DRB APPLICATION NO. 02 DRB 01005	DRB PROJECT NO. 1002069
PROJECT NAME Rhodes Acres Add.	
EPC APPLICATION NO.	
APPLICANT Aldrich Land Surveying	PHONE NO. 884-1990
ZONE ATLAS PAGE E 18	
<b>ONE STOP CASE TRACKING LOG</b>

**Re: Plat - RHODES ACRES ADDITION, TRACT D-1 AND D-2**

**PLAT FOR
TRACT D-1 AND D-2
RHODES ACRES ADDITION
WITHIN THE
ELENA GALLEGOS GRANT
PROJECTED SECTION 25
TOWNSHIP 11 NORTH, RANGE 3 EAST, NMPM
CITY OF ALBUQUERQUE
BERNALILLO COUNTY, NEW MEXICO
JUNE, 2002**

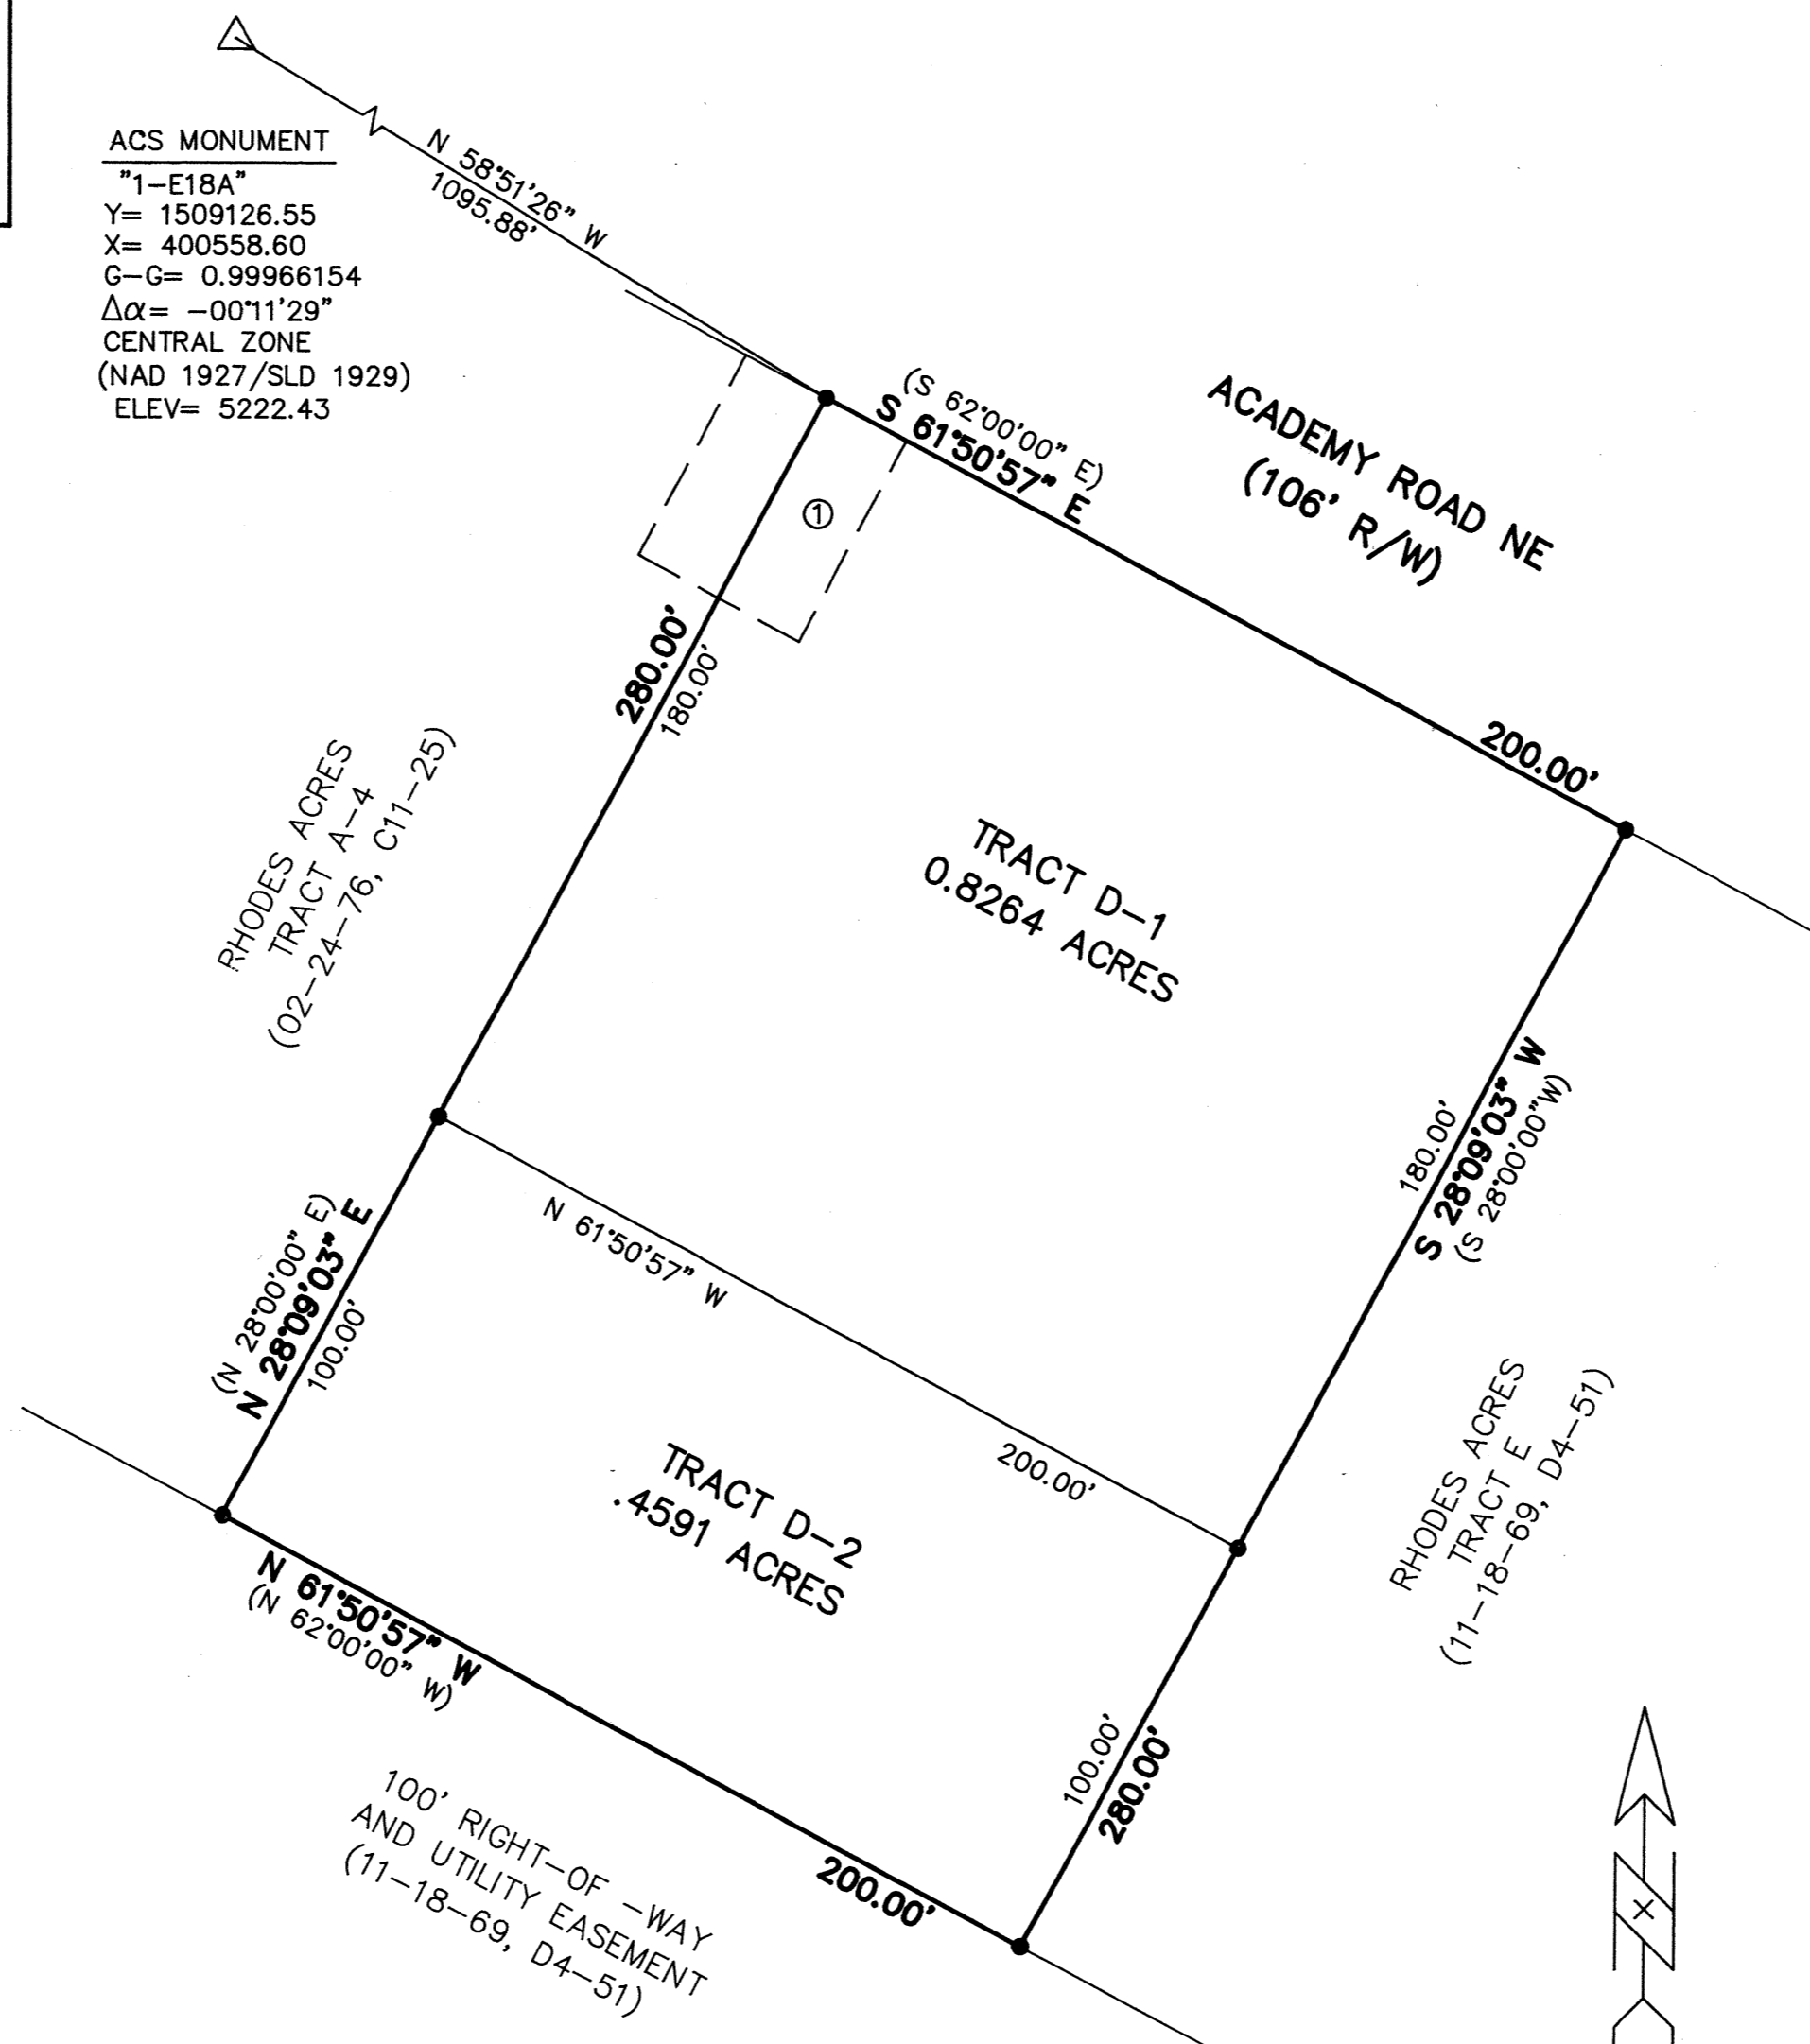
<b>TRANSPORTATION DEV (505) 924-3990</b>			
PLANS DISAPPROVED X NSF	DATE 7/1/02	DATE	DATE
PLANS APPROVED RD	DATE 7-23-02	DATE	DATE
COMMENTS:			
- Specify on plat the lot/owner that will maintain access easement			
- show where access easement betw. Tract D-1 & D-2 will be located			
- Provide site sketch

<b>UTILITY DEV (505) 924-3989</b>			
PLANS DISAPPROVED R/S	DATE 7/2/02	DATE	DATE
PLANS APPROVED R/S	DATE 7/23/02	DATE	DATE
COMMENTS:			
- Need site plot Plan, why is lot being subdivided? - Sell to Tract A-4			
- Tract D-2 has no access to water/sewer service. - Done

<b>HYDROLOGY DEV (505) 924-3986</b>			
PLANS DISAPPROVED BLB	DATE 7/2/02	DATE	DATE
PLANS APPROVED <del>BLB</del> BLB	DATE <del>7/2/02</del> 7/24/02	DATE	DATE
COMMENTS:			
1) Label "Drainage" R/w (Public) on south end.			
<del>2) All drain labels recorded</del>
